County File: ANX-23-30
City File: ANEX-22-0014

Re: Colorado Centre Addition No 3 - Annexation Plat (5509101002)

ANNEXATION PLAT
COLORADO CENTRE ADDITION NO. 3

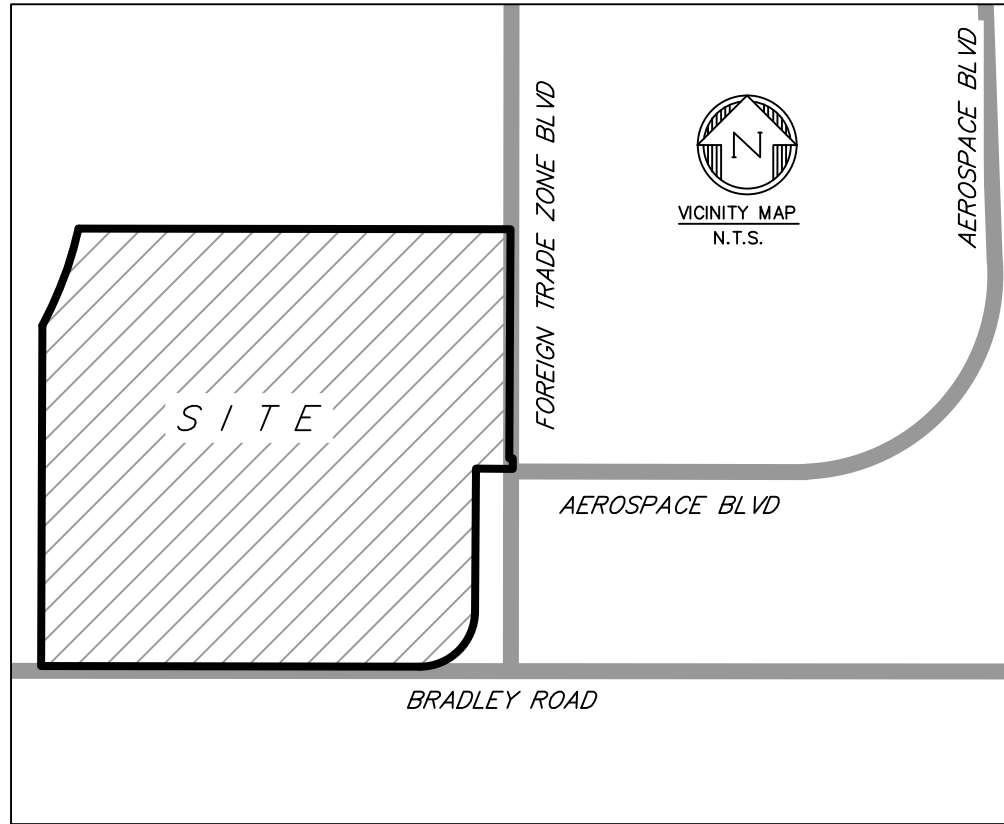
1. The City should annex the remaining County portion of Foreign Trade Zone Blvd. to the north if this project is approved.
